From: Nina Sidhu <Nina.Sidhu@arun.gov.uk>
Sent: 17 September 2019 17:02
To: Zac Denton <Zac.Denton@arun.gov.uk>
Cc: Kate Giddings <kate.giddings@arun.gov.uk>
Subject: RE: 23 Sea Road

Thank you for the information provided. I regret however, that we still do not have an assessment of the noise the cooler and the associated ducting will make and whether this could impact adversely on the nearest sensitive noise receptor. We appreciate that the plant is not located externally but we do not know the effect of the ducting on the noise e.g. Will the noise be amplified or funneled by the ducting. If we do not receive this information we cannot endorse discharge of the condition. If you were to go ahead with the work as proposed and there was noise nuisance from the cooler outlet, we would need to take action under the Environmental Protection Act 1990. This could involve you in having to undertake costly remedial work to abate the nuisance. This is why we are asking for sufficient information to be provided at this stage.

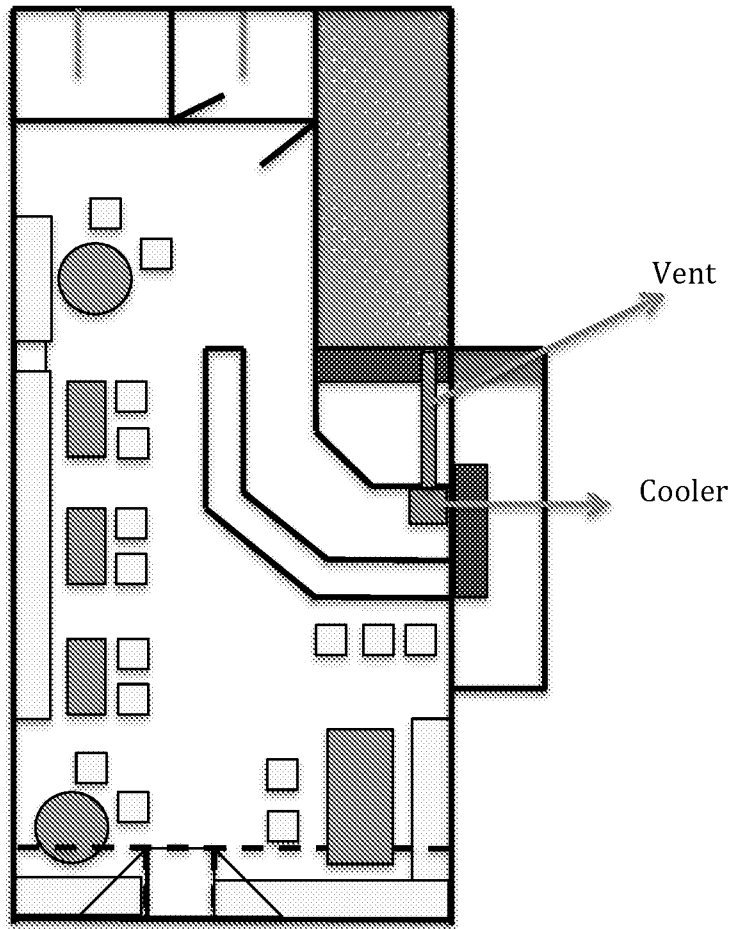
In order for us to be satisfied that there will be no adverse noise impact we recommend a BS:4142 assessment is carried out by a suitably qualified, independent acoustician.

- *what is the distance between the cooler and the termination point of the ducting?
- *what material(s) is/are being used for the ducting?
- *how will vibration from the plant and associated ducting be managed?
- *at what height does the ducting terminate?
- *how far is the termination point from the nearest noise sensitive receptor?
- *when will the cooler/ducting be in operation (for example, when the premises is open/when the temperature rises above a certain threshold/all the time)?

The distance from cooler to ducting termination is approx 2.5m.

Plastic ducting held in place with fastening clips and boxed in to top of cool room below new lowered, soundproofed ceiling.

Anti vibration pads for plant and anti vibration clips for ducting.

Ducting terminates at approx 2.4m off FFL

Extraction outlet will be approx 1.5m below the upstairs window, However, there will be no plant on the external or internal wall, as it will only be a vent as the cooler unit will blow the air through the ducting directly.

The cooling unit will only operate when the cooling room drops to a certain temperature. This will be greatly reduced at hrs we are closed due to all doors being closed to the cool room.
